Online Comment

Application H16-0817-23
Location Land off Roman Bank Spalding Lincolnshire
Proposal Details of external materials, landscaping and tree planting, contamination of land or pollution of controlled waters, proposed boundary treatments, storage and disposal of refuse and recycling, Construction Management Plan and Method Statement, communal space and cycle racks (Conditions 5, 6, 7, 9, 10, 11, 12 and 13 of H16-0523-22)

Name Sue Armour
Address Environmental Protection Officer SHDC

I have reviewed the Elemental GI Ltd report 'PHASE 2 GEO-ENVIRONMENTAL INVESTIGATION FOR SITE OFF ROMAN BANK, SPALDING' Project No: E22209 Ref No: E22209/2/0 Date: Jan. 2023.

Site Investigation Plan

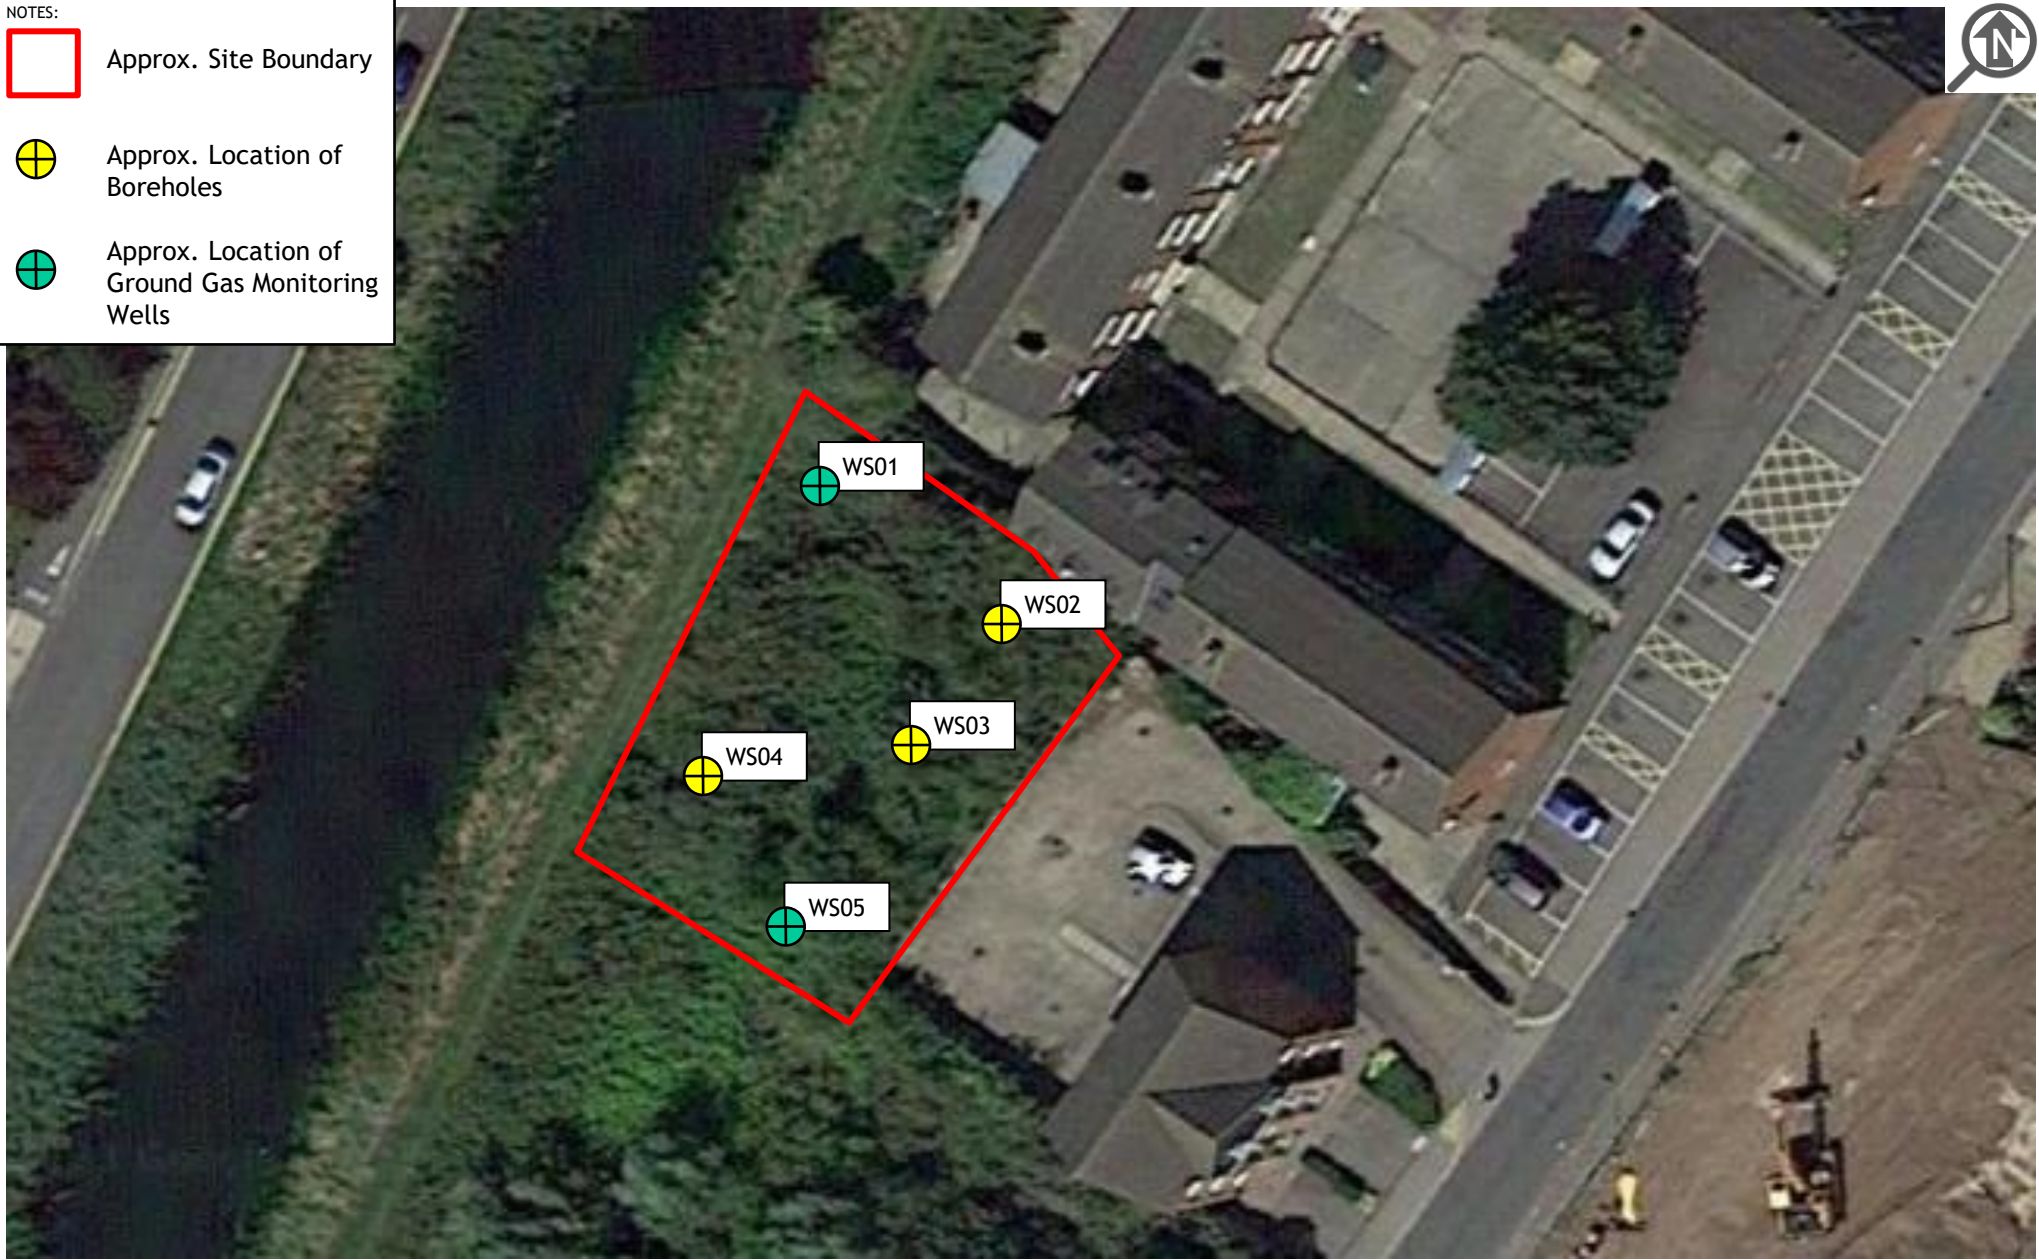
The report identified an area of hydrocarbon contamination in the area of WS4. Only one soil sample was analysed and this did not identify elevated levels in this context, however the report noted that there was a noticeable hydrocarbon odour in the ground water in this location and in other locations. The potential pathway of vapour arising from groundwater impacting on the future residents has not been considered.

Three ground gas monitoring visits were undertaken which showed slightly elevated levels carbon dioxide. However, WS04 was not a monitoring location.

It would be my preference to see sampling of the groundwater and further ground gas monitoring to characterise the site further and demonstrate that the proposed remedial solution is appropriate in this instance, and to consider the potential for impact to controlled waters.

I feel these works could be considered as part of a remedial design phase, and therefore recommend discharge of part ii of condition 7 of H16-0523-22, with part iii and condition 8 remaining outstanding. Please pass my comments to the applicant and I look forward to receiving the remediation method statement in due course.
